PLANNING AMENDMENT

Application No. H17/0021/01/A2

Description: Conversion of methodist church
to dwelling

**Conversion of Methodist Church to dwelling at
Station Road, Surfleet, Spalding, Lincs
Reference No: H17/0021/01**

Drawn
 JPW

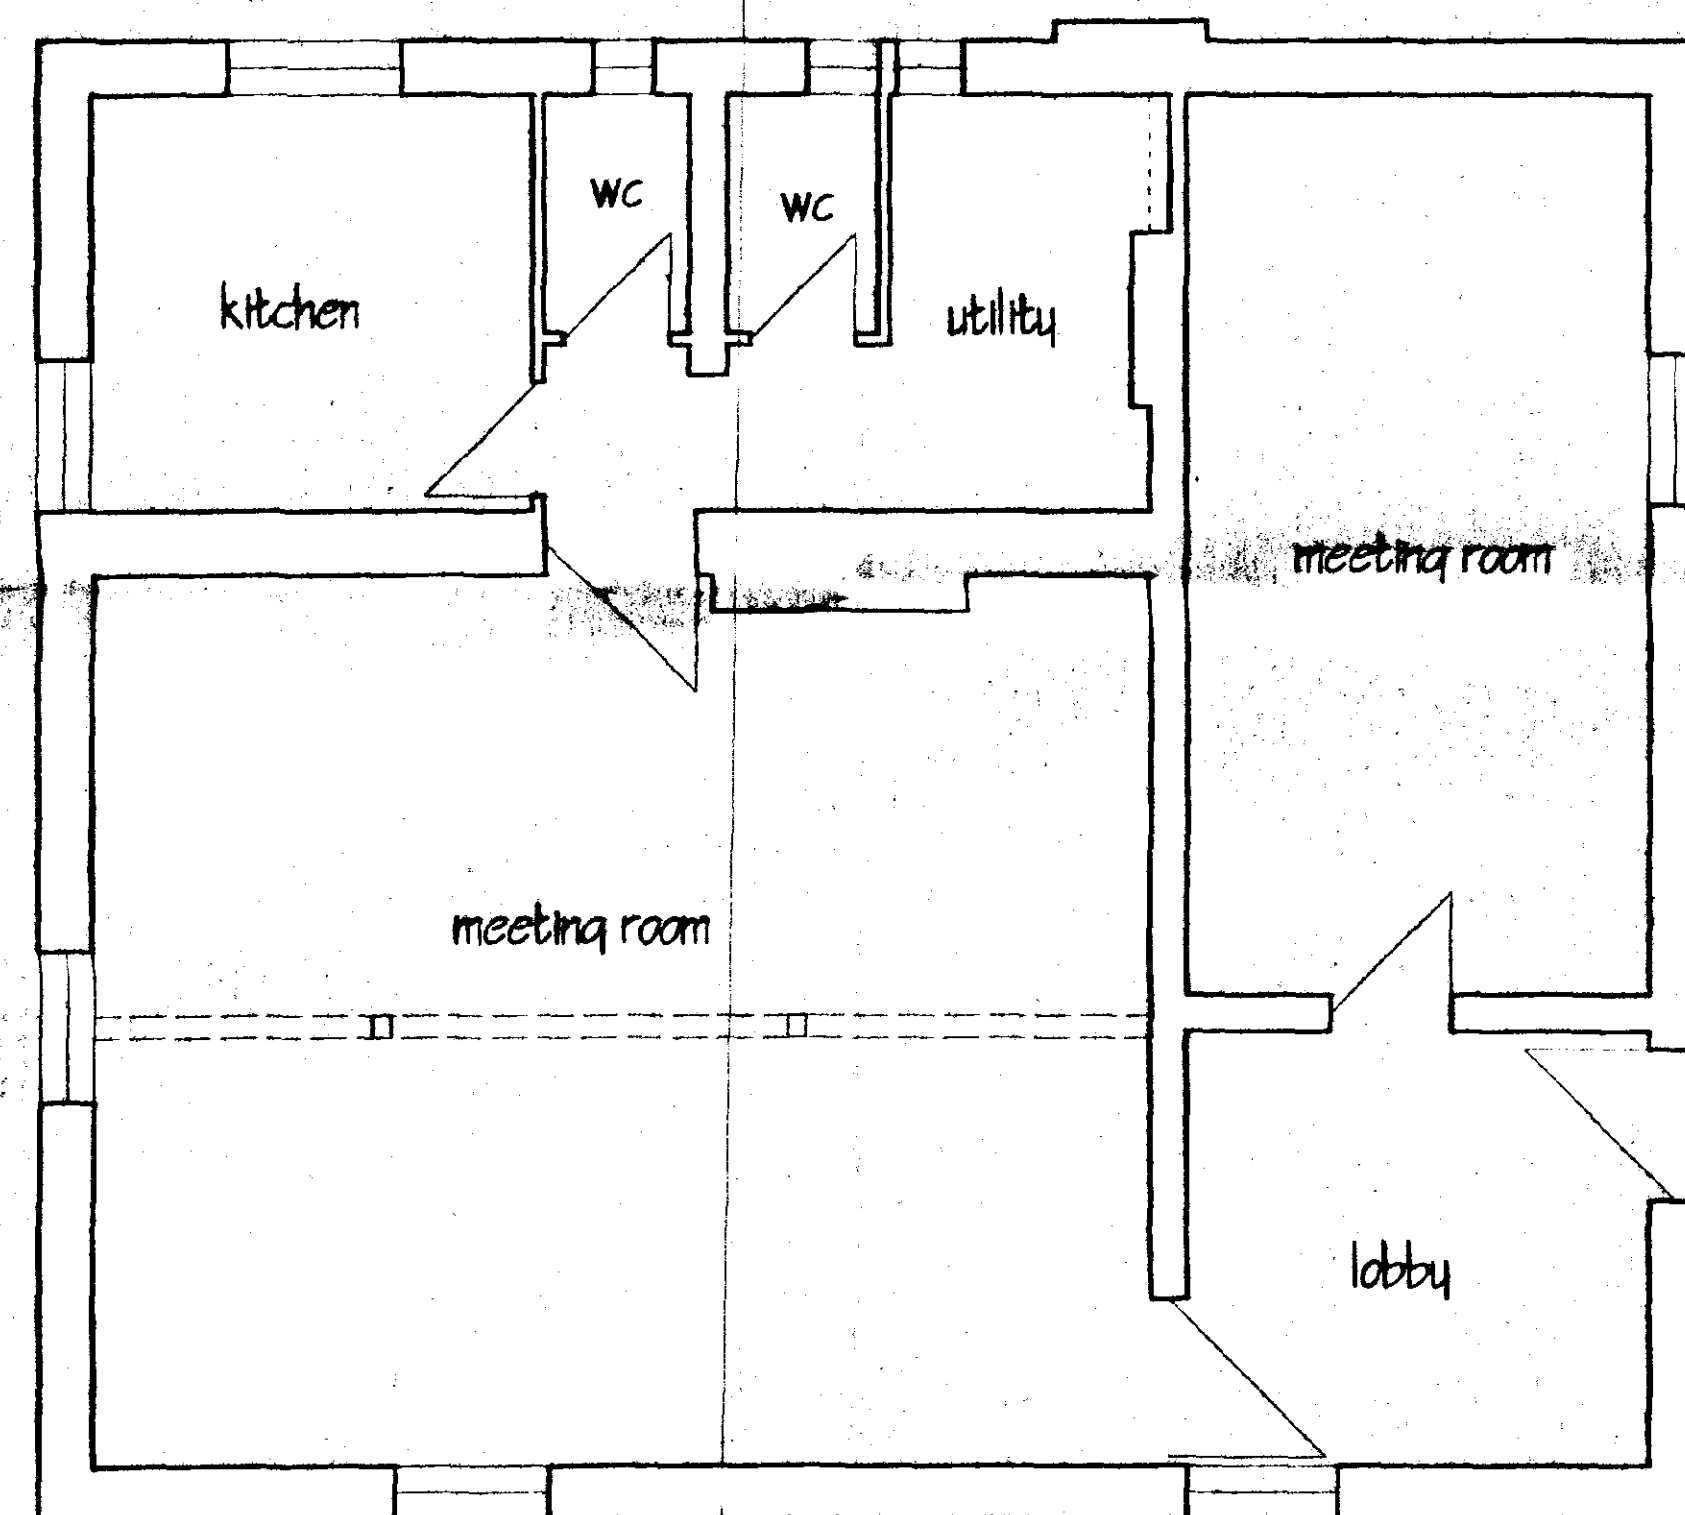
- 1) The balcony design, which will be submitted as a Condition Compliance.
- 2) The change to the cill height of the new window to the dining area. Such a change is contrary to Condition 9 and therefore Planning Permission is required. The window as shown on the scheme prepared by G.R. Merchant on drawing number 138/00/02, can be installed in accordance with the Planning Permission.

14 250 - 15

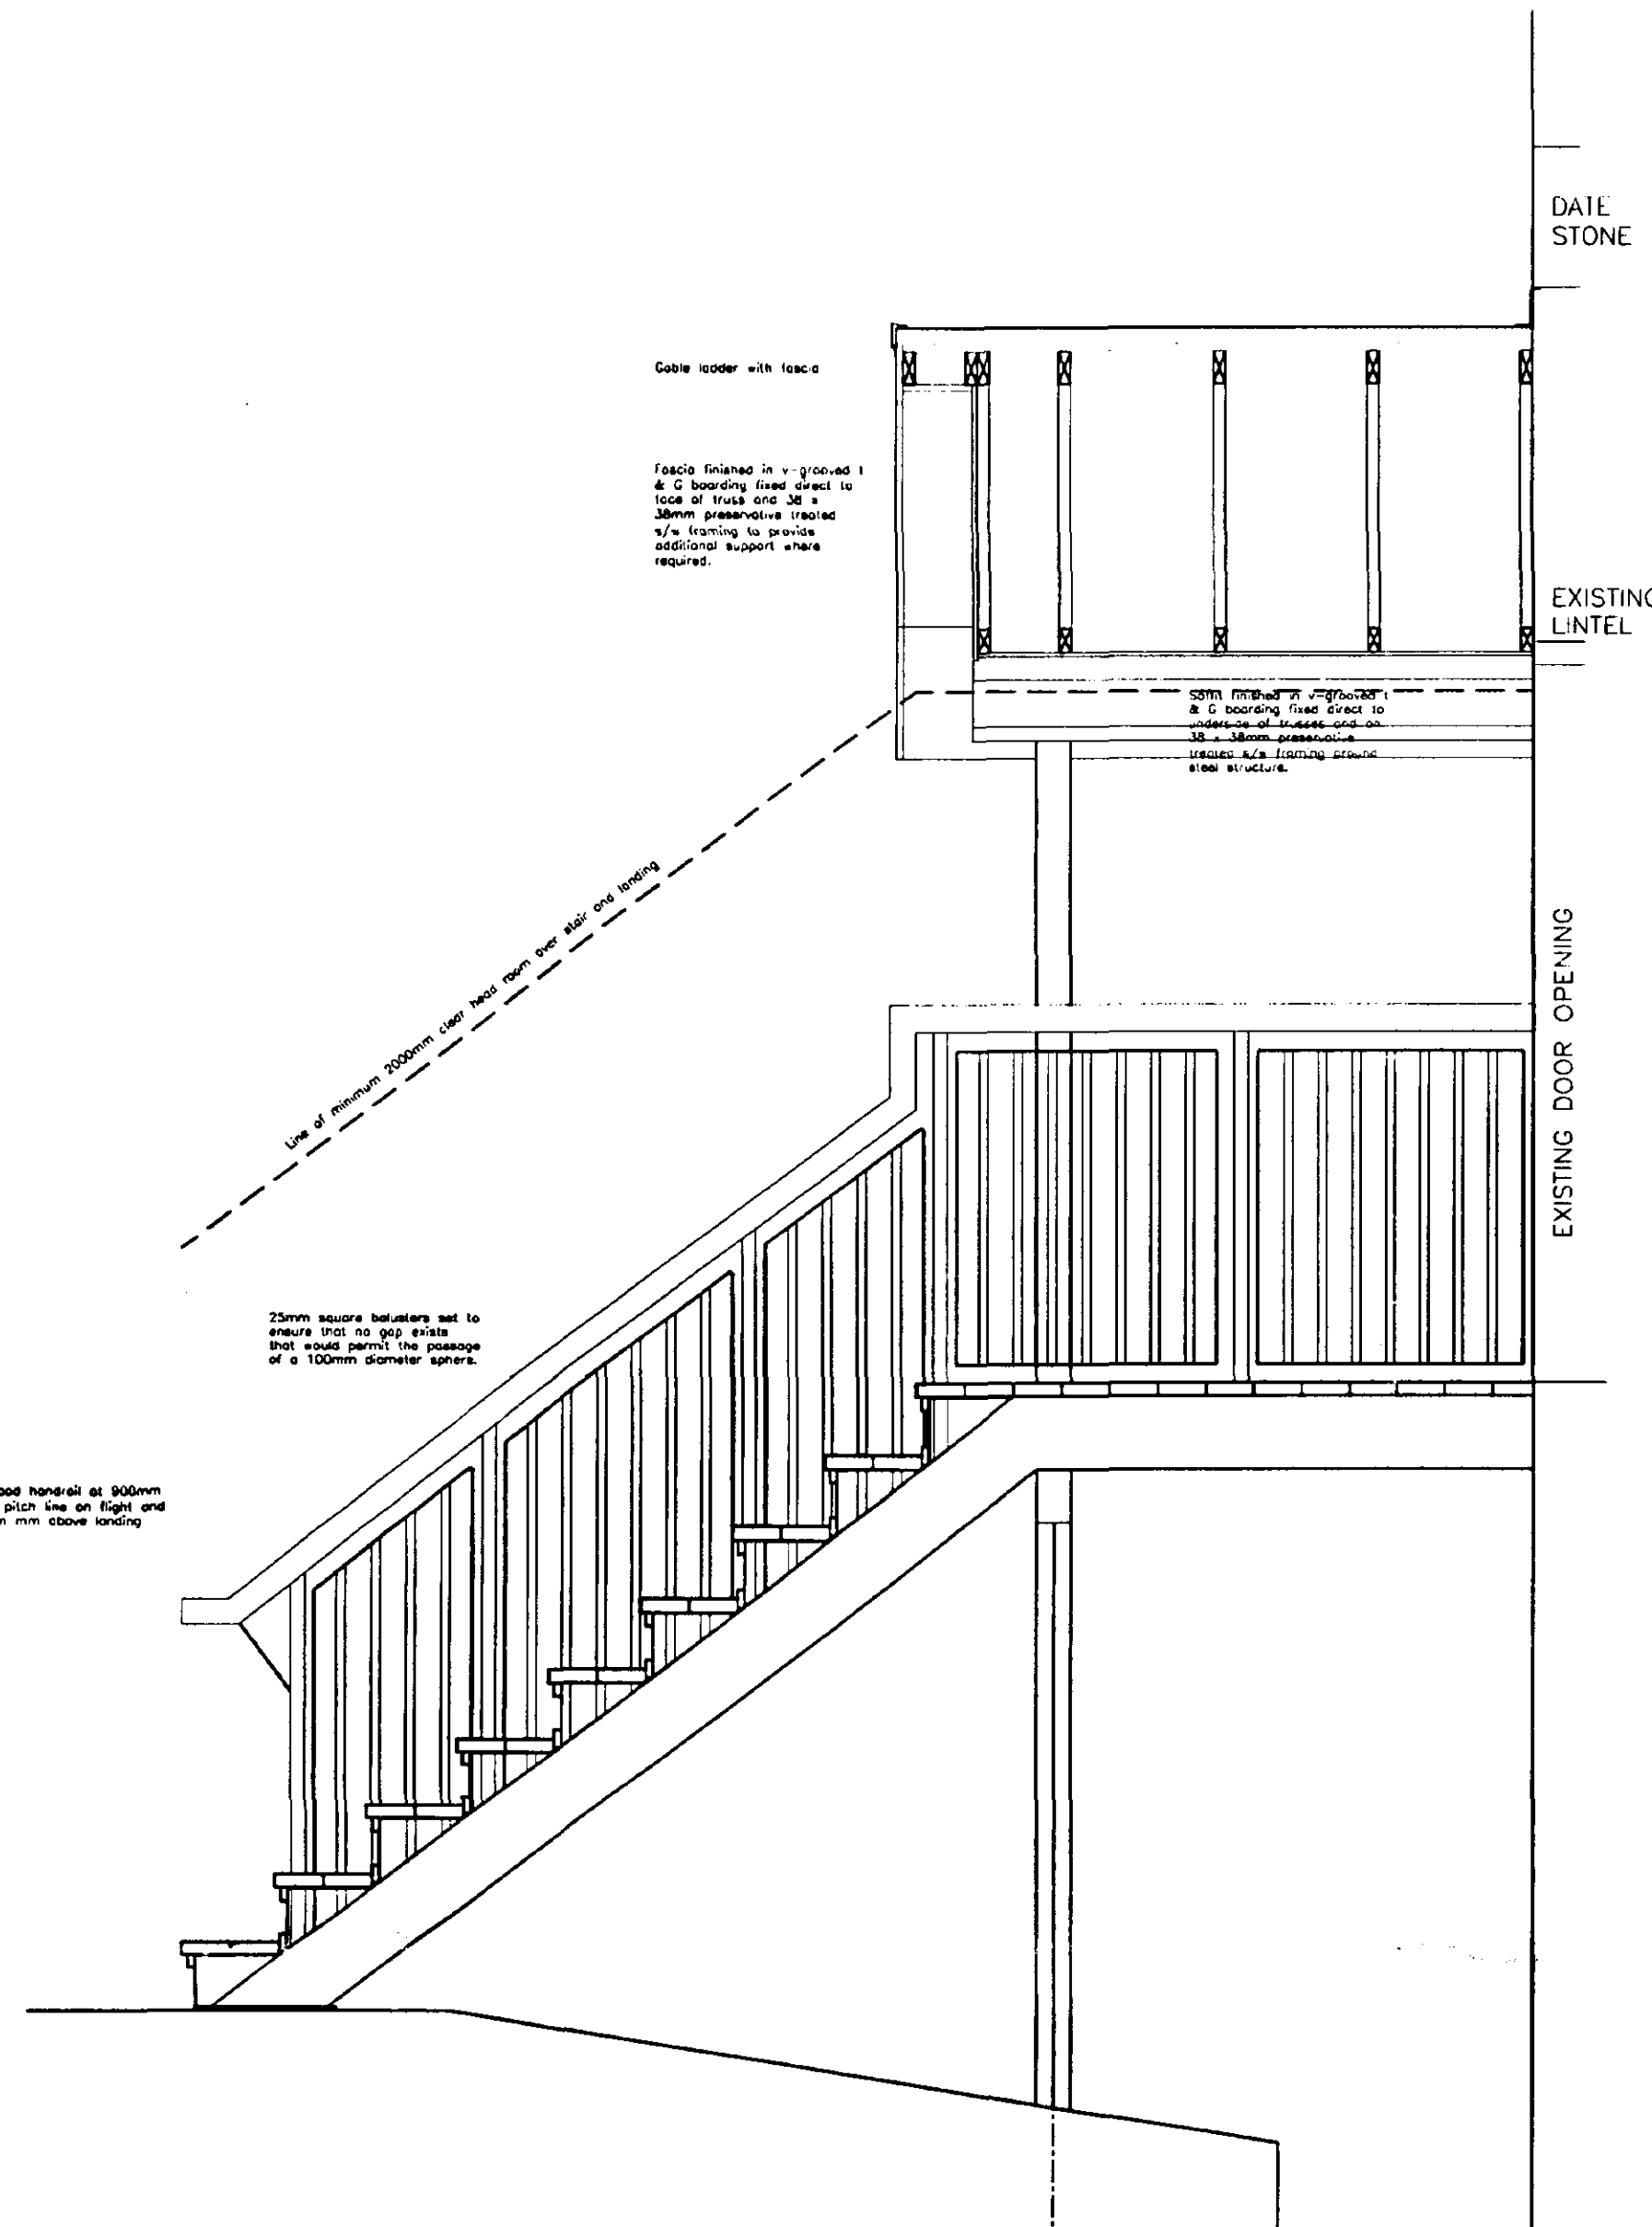
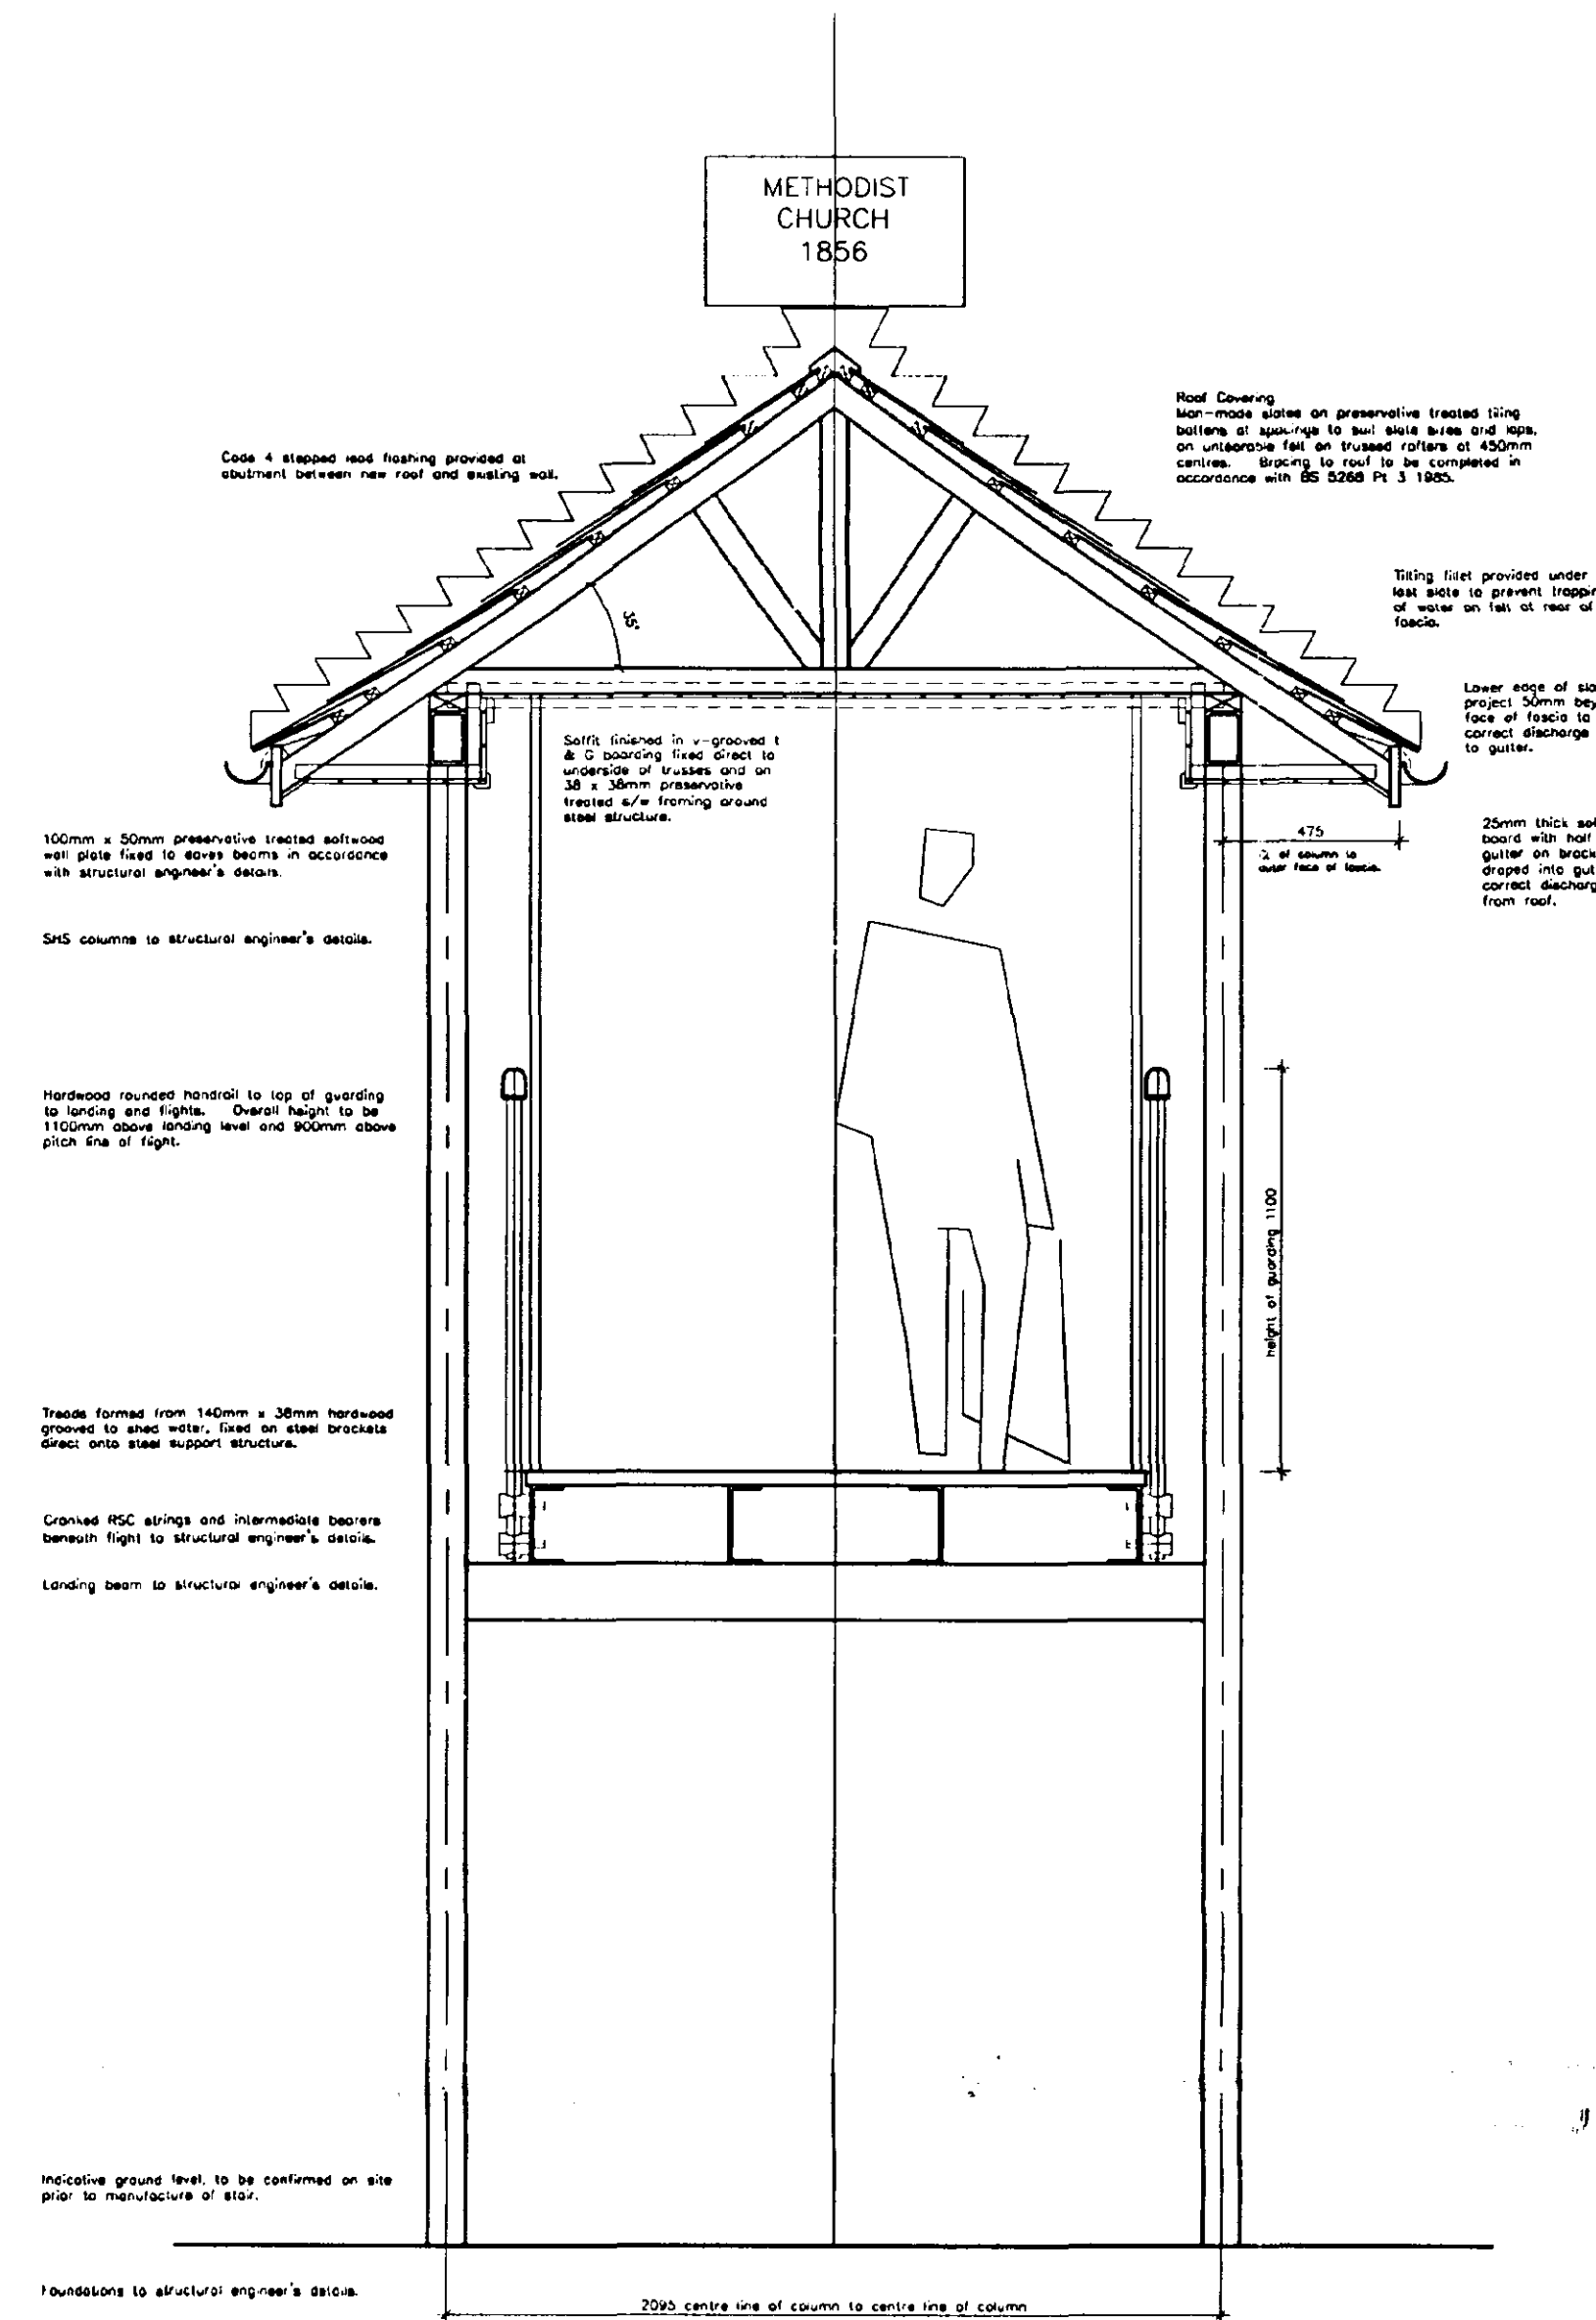
8. The balcony design has been changed and the roof canopy over has been omitted. Trellis and plant screening has been introduced to reduce overlooking of the adjacent property. In this respect we have illustrated our proposals to discharge condition number 5 of the original approval.
